Re: 4242230

Pages or sheets covered by this seal: T35954402 thru T35954404

Job 4242230	Truss E3	Truss Type Attic Girder	Qty 1	Ply 1+1	Units: 1.0 Eng: T.L T35954403
----------------	-------------	----------------------------	----------	------------	-------------------------------------

REPAIR: REPLACE 1-PLY OF TRUSS E3 WITH 1-PLY OF TRUSS E1.
SEE PAGE (2 OF 3) FOR E1 DETAIL.

Job 4242230	Truss E1	Truss Type Attic Supported Gable	Qty 1	Ply 1	Job Reference (optional)
----------------	-------------	-------------------------------------	----------	----------	--------------------------

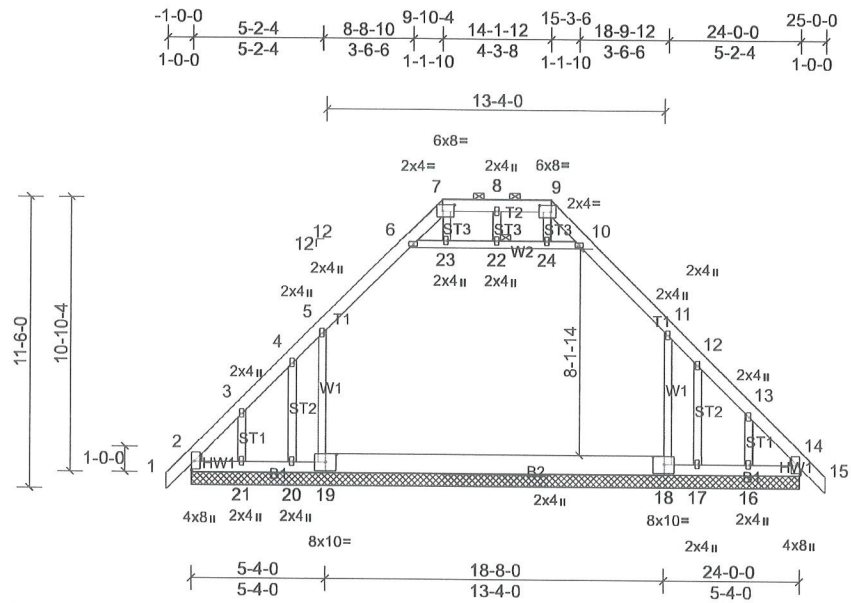
REPAIR: REMOVE RIGHT END OVERHANG.

ATTACH THIS TRUSS TO E3 ON PAGE (1 OF 3) TO FORM A 2-PLY TRUSS.

LUMBER (SHOWN DASHED) TO BE CUT CLEANLY AND ACCURATELY AND PLATE(S) MUST BE FULLY EMBEDDED AND UNDISTURBED.

ATTACH 1/2" PLYWOOD OR OSB GUSSET (15/32" RATED SHEATHING 32/16 EXP 1) TO ONE FACE OF TRUSS OPPOSITE OF E1 WITH (0.113" X 2") NAILS PER THE FOLLOWING NAIL SCHEDULE: 2 X 6'S - 3 ROWS: SPACED @ 2" O.C. INTO EACH COVERED TRUSS MEMBER. USE 2" MEMBER END DISTANCE.

Job 4242230	Truss E3	Truss Type Attic Girder	Qty 1	Ply 2	Job Reference (optional)
----------------	-------------	----------------------------	----------	----------	--------------------------

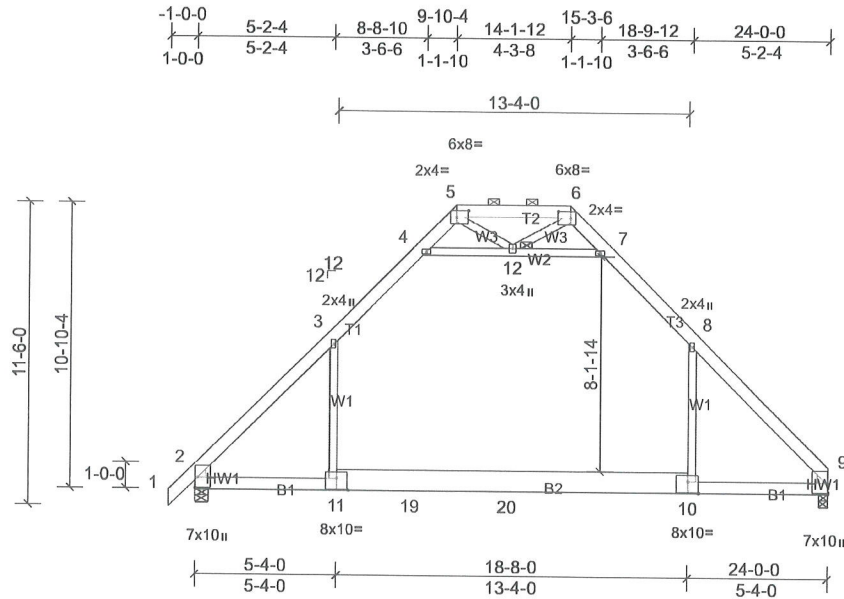
APPLY 2 X 6 SP NO.2 SCAB TO ONE FACE OF TRUSS OPPOSITE OF E1 AS SHOWN. ATTACH WITH (0.131" X 3") NAILS PER THE FOLLOWING NAIL SCHEDULE: 2 x 6'S - 2 ROW: SPACED @ 6" O.C. USE 2" MEMBER END DISTANCE.

ATTACH E1 TRUSS TO ONE FACE OF (1-PLY) E3 TRUSS WITH (0.131" X 3") NAILS (INTO ALL ALIGNING MEMBERS) PER THE FOLLOWING NAIL SCHEDULE: 2 x 4's - 2 ROWS, 2 x 6'S AND LARGER - 3 ROWS: SPACED @ 6" O.C. USE 2" MEMBER END DISTANCE.

Job 4242230	Truss F1	Truss Type Piggyback Base	Qty 2	Ply 1	Job Reference (optional)
----------------	-------------	------------------------------	----------	----------	--------------------------

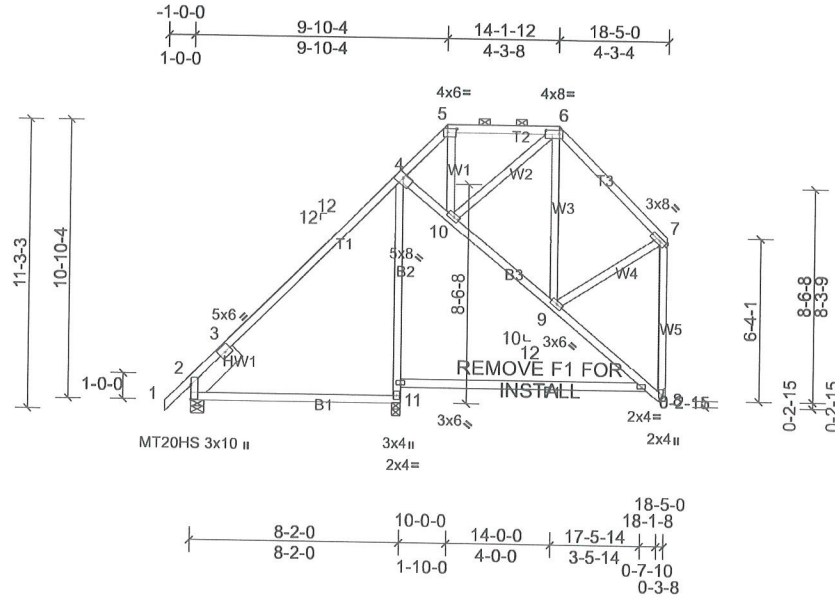
**REPAIR: REMOVE NON-STRUCTURAL WEB {8-11}
NO REPAIR IS REQUIRED.**
